Rezoning Transportation Analysis

Petition Number: 2020-109

Revision Log:

Date	Description
09-18-20	First Review

EX01-REZONING PLAN

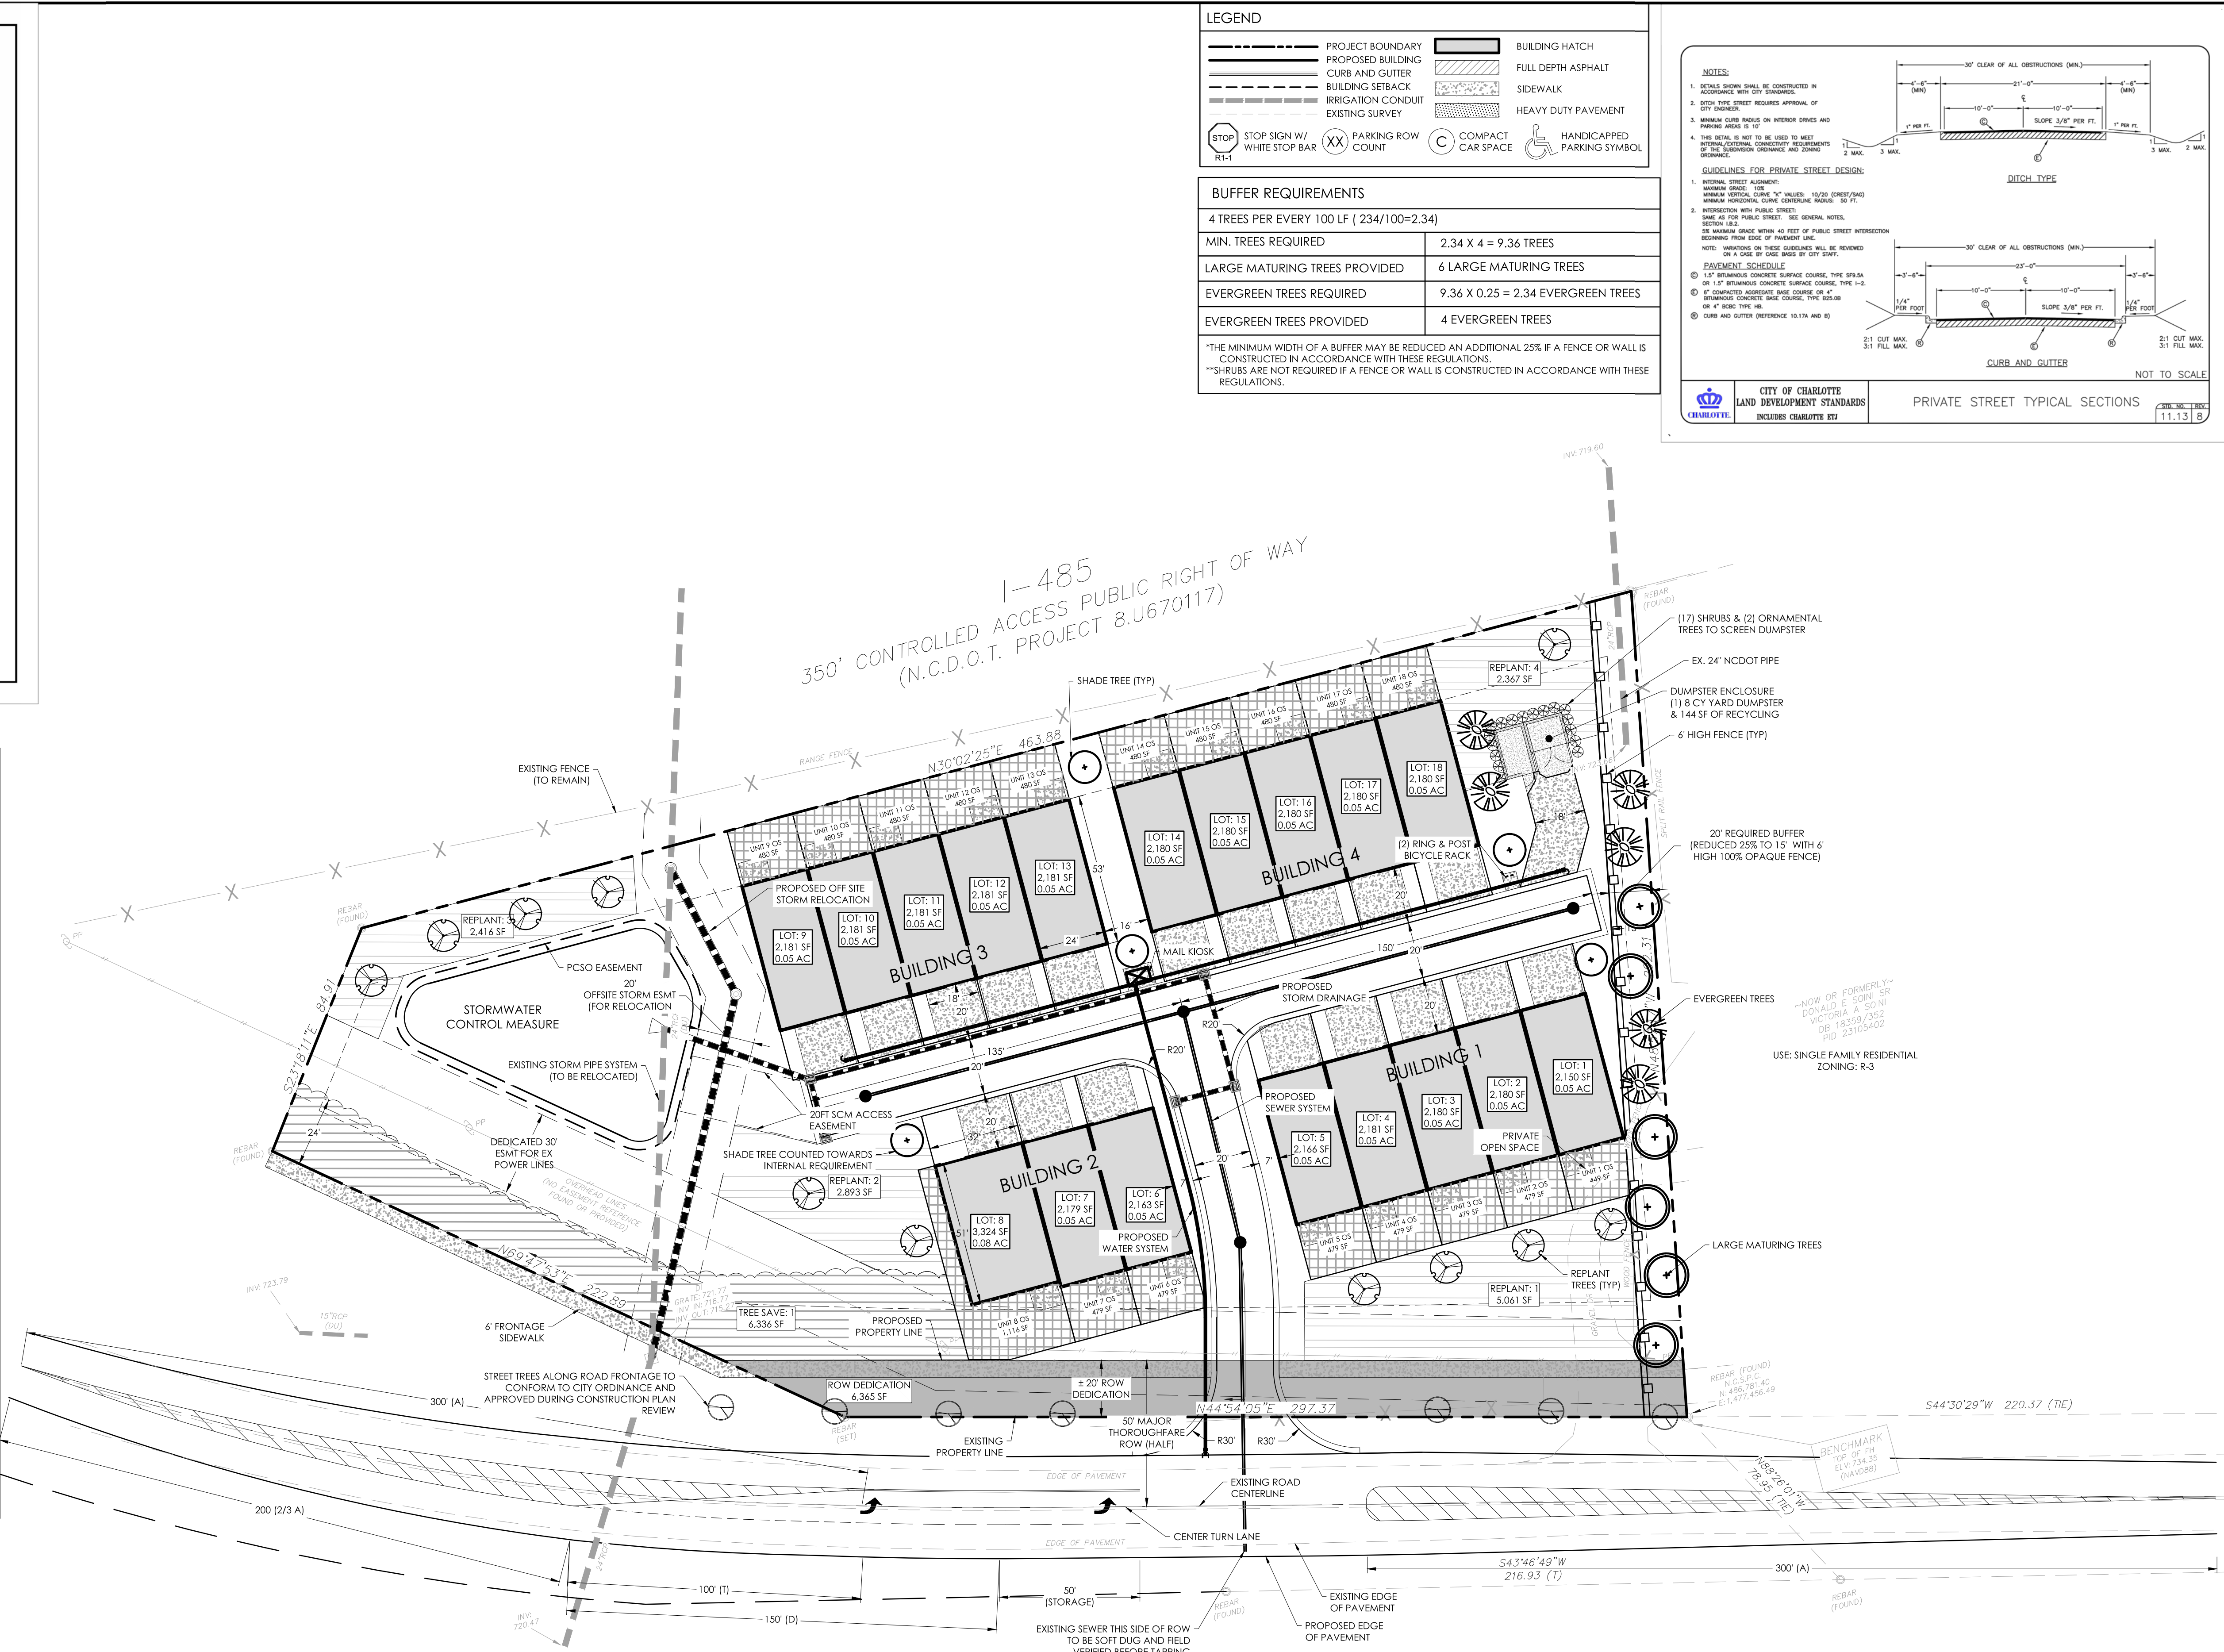
McKee Road (NCDOT): The future location of back of curb and gutter is 30' from the McKee Road centerline. The curb and gutter needs to be labeled and dimensioned from the road centerline to the back of curb on the site plan.

Begin the Multi Use Path where the property line changes direction and runs parallel with McKee Road.

4. Pedestrian sight triangles (NCDOT 10'x70') at the McKee Road driveway connection need to be reflected on the site plan. Label all roadways as private streets, where appropriate.
5. Provide ISD along McKee Road for driveway, both horizontal and vertical included to show standard meets NCDOT standards.
6. Add a note specifying all transportation improvements will be approved and constructed before the site's first building certificate of occupancy is issued. The petitioner may phase transportation improvements if said improvements and phasing are explicitly described in site plan notes.
